Project Name/Description

539 - 539 Auburn St , Portland, Maine

RE: Final Site Inspection, (Project # 2006-0087), (CBL 382A D 021001)

RE: C. of O. for 539 Auburn Street
(Id#2006-0087)(CBL 382A D 021001)

GRADING PLAN
OF:
LOT 1 AUBURN ESTATES
LONGVIEW DRIVE
PORTLAND, MAINE
FOR:
BRUSH AND HAMMER INC.
110 LESTER DRIVE
PORTLAND, MAINE 04103

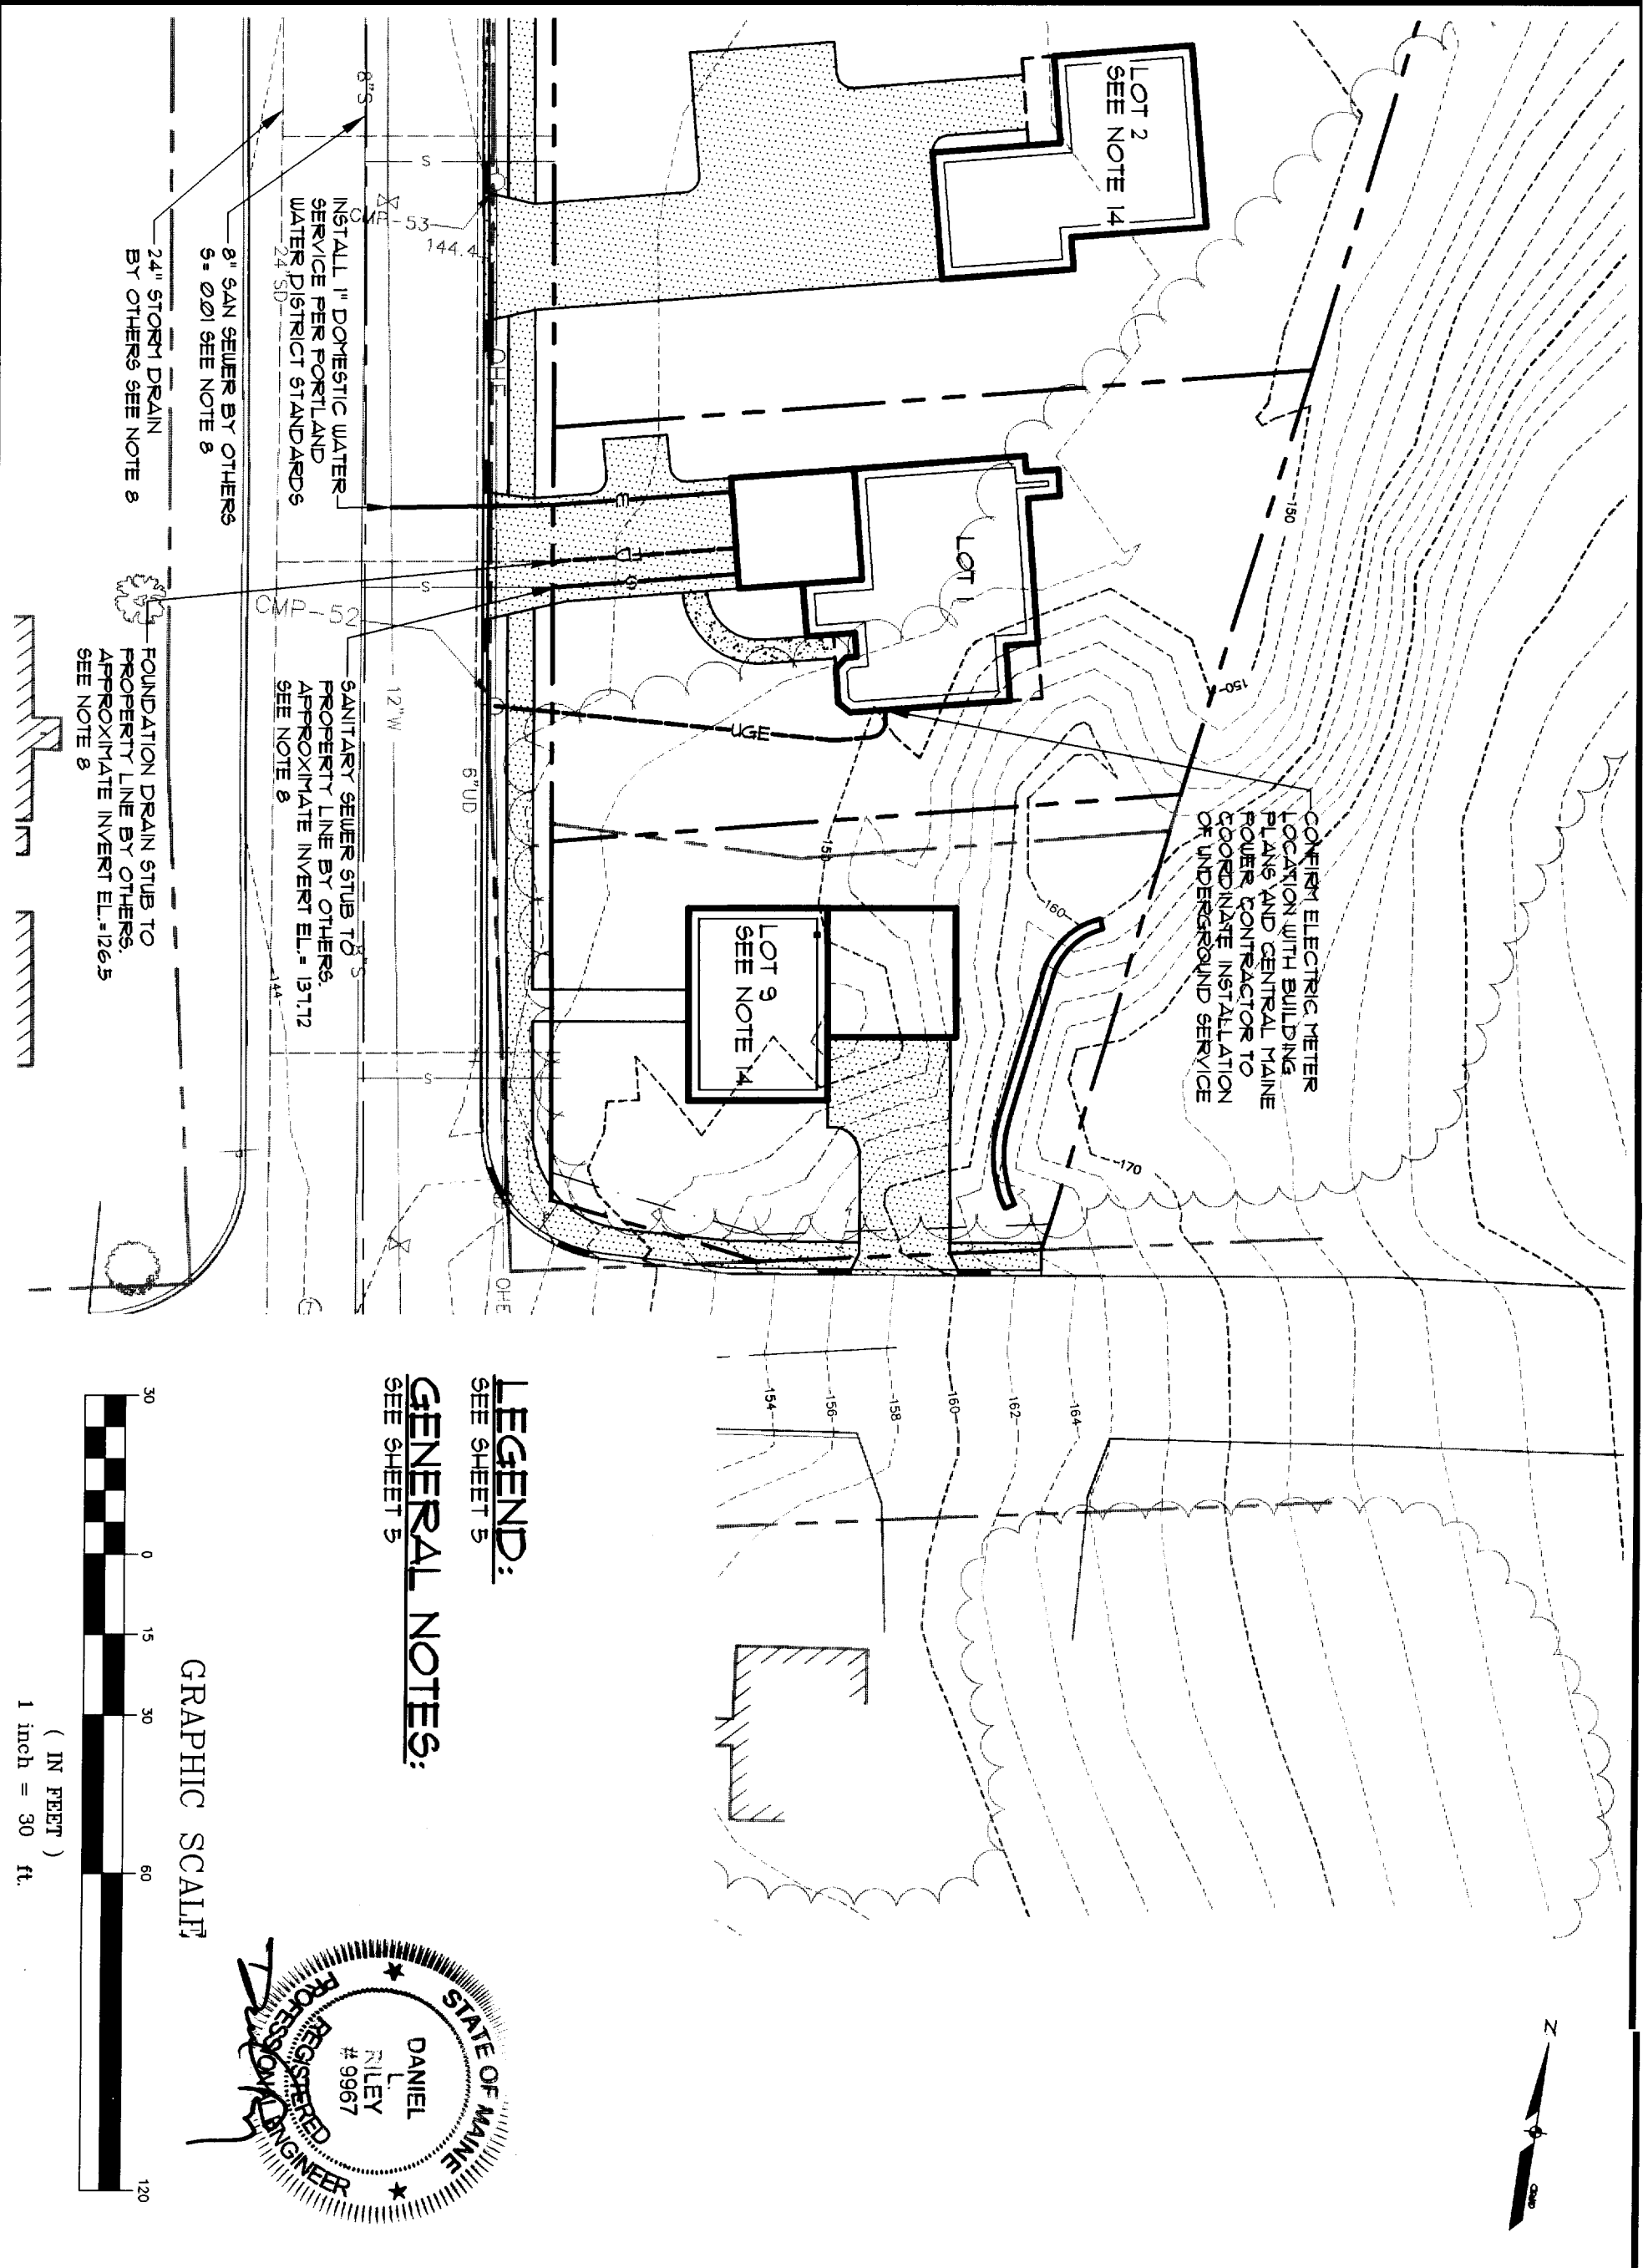
1. Final grading per the approved site plan; the grade along both sides and the front of your house appears to be pitched toward the house causing water to drain toward the foundation. Per the approved site plan, the grade should be pitched away from the foundation toward the street,
2. Loaming and seeding of all disturbed areas,
3. Two (2) City of Portland approved species and size trees must be planted on your street frontage. The trees must be a minimum 2 to 2 1/2 caliper in size.

Regarding your letter: We have graded the area with proper runoff, loamed and seeded all areas, and planted two 2" red maple trees at the front of the property.
